Appendix

Conservation Management Plan (CMP)

The bullet-pointed text below denotes advice and recommendations that Historic England gave regarding the CMP as part of our consultation response to the 2019 planning application. We have provided additional comments and recommendations below this initial advice; where it may be helpful and relevant.

Project		Fort Halstead	
Drawing		Tree Retention Plan for Outline Planning Page	
Client		CBRE	
Scale	1:2,500	Revision	Rev A
Date	June 2020	Author	DS
Checked by	GT

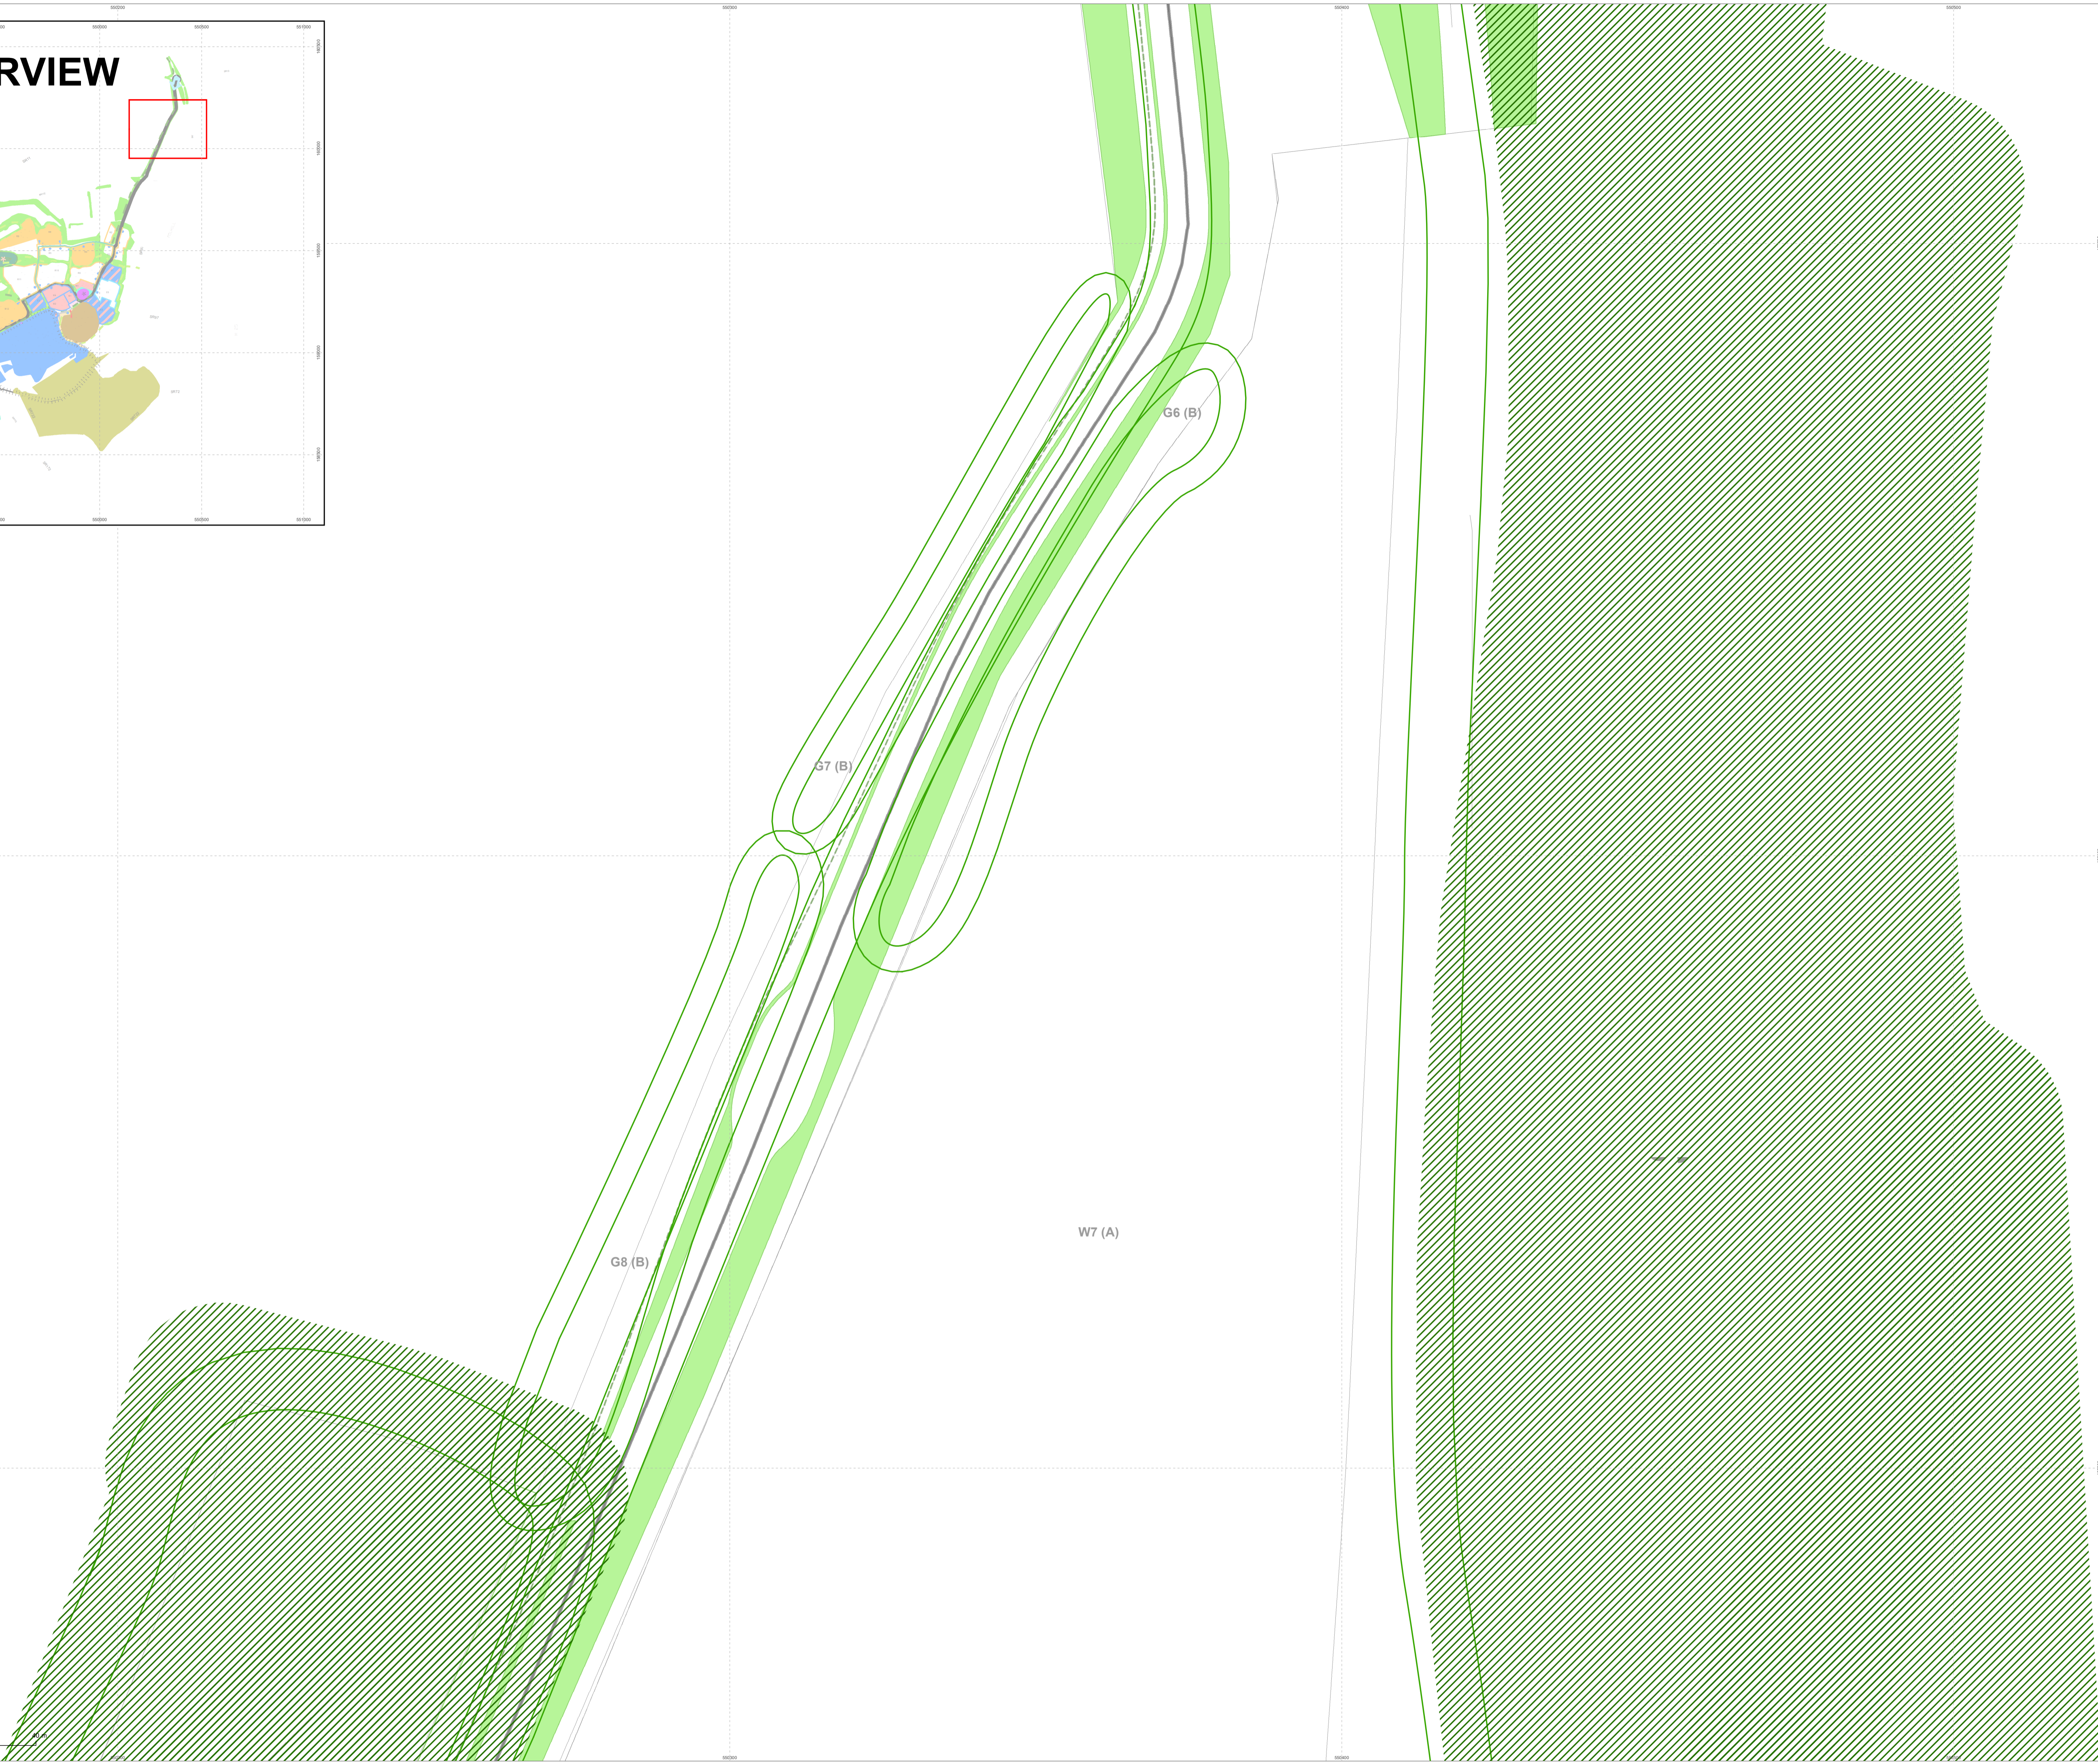
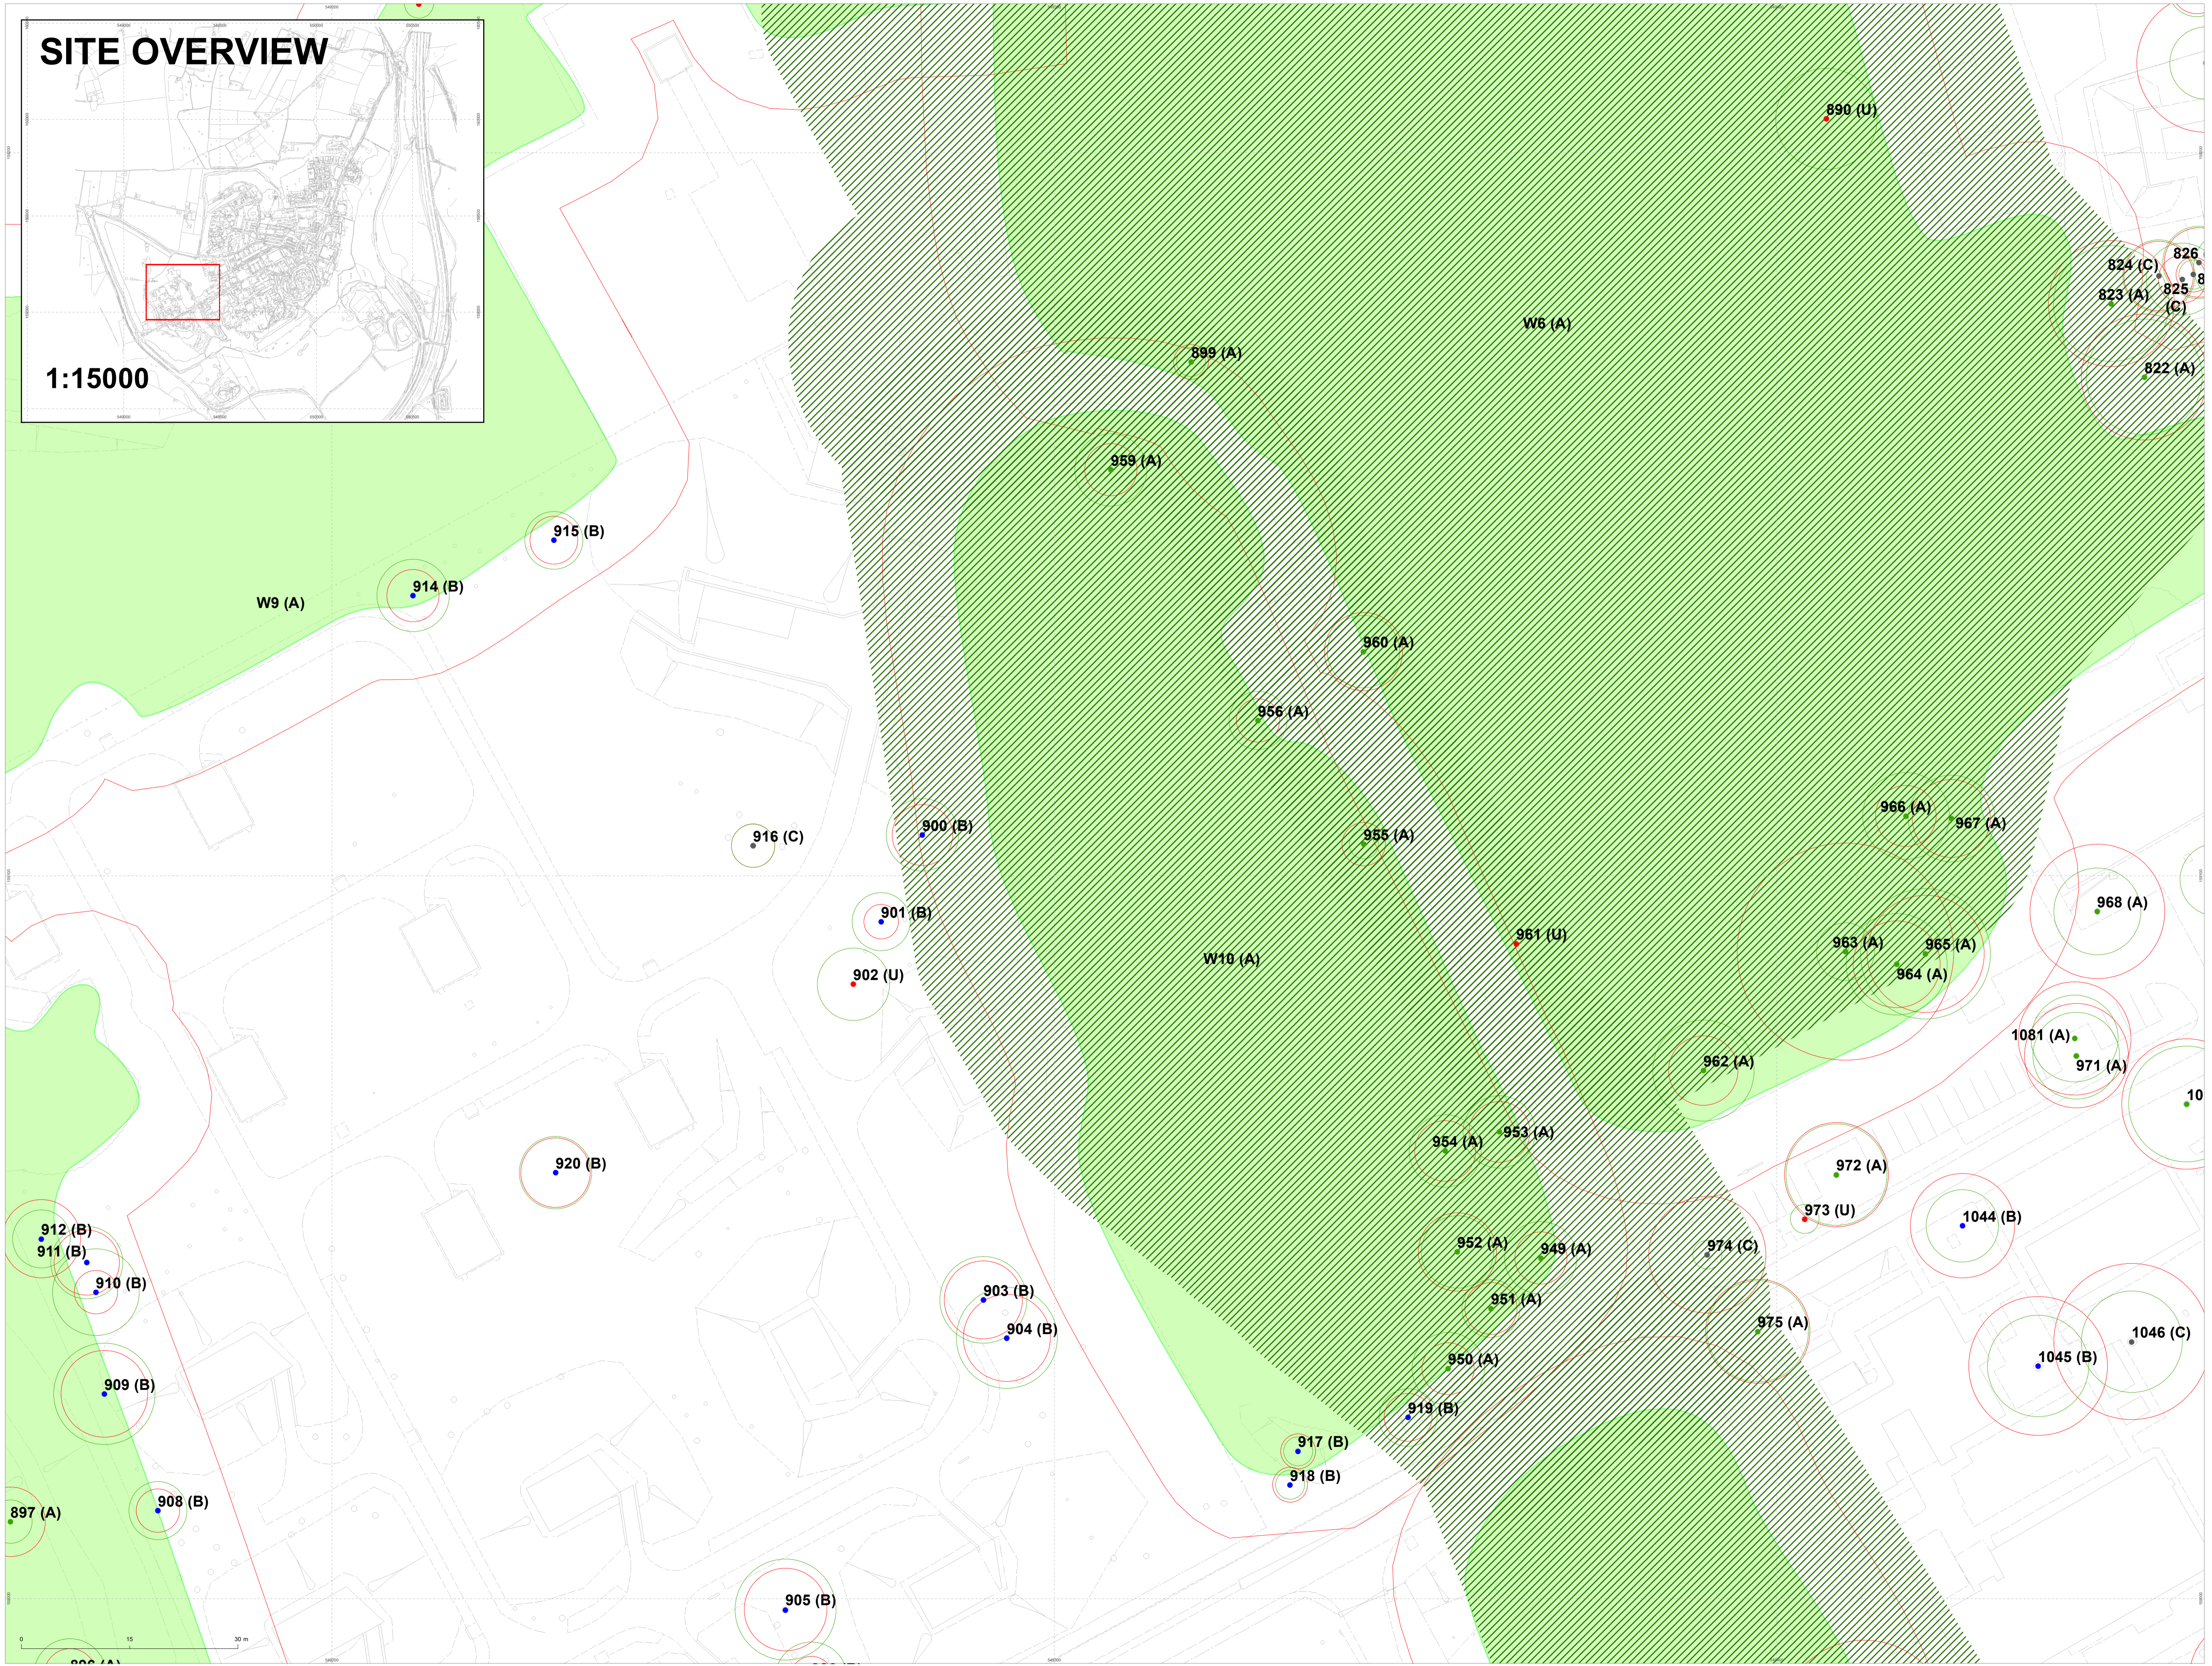
- 3) “More information should be provided regarding provision to reveal key views and aspects of the fort’s setting.”

We are pleased to see that the revised CMP includes acknowledgement of the need to reveal key views and aspects of the fort’s setting. However, currently the report

does not progress beyond an intention to provide for this, and includes no more detailed information on the specific aims or proposed methodologies for such. We recommend that further assessment and consideration should be given to:

- Which specific key views/aspects of setting should be revealed and thus which areas of vegetation/trees will require removal
 - Whether tree removal/retention will have any structural impact on the historic fort (as informed by an arboriculturalist)
 - Whether any ecological considerations will need to be taken into account (as informed by consultation with Natural England).
- 4) “Agreement of the details of the structure, governance and funding of a community trust or management company, which should demonstrate specific duties and protections with respect to the conservation of the fort and any other heritage assets for which it will be responsible.”
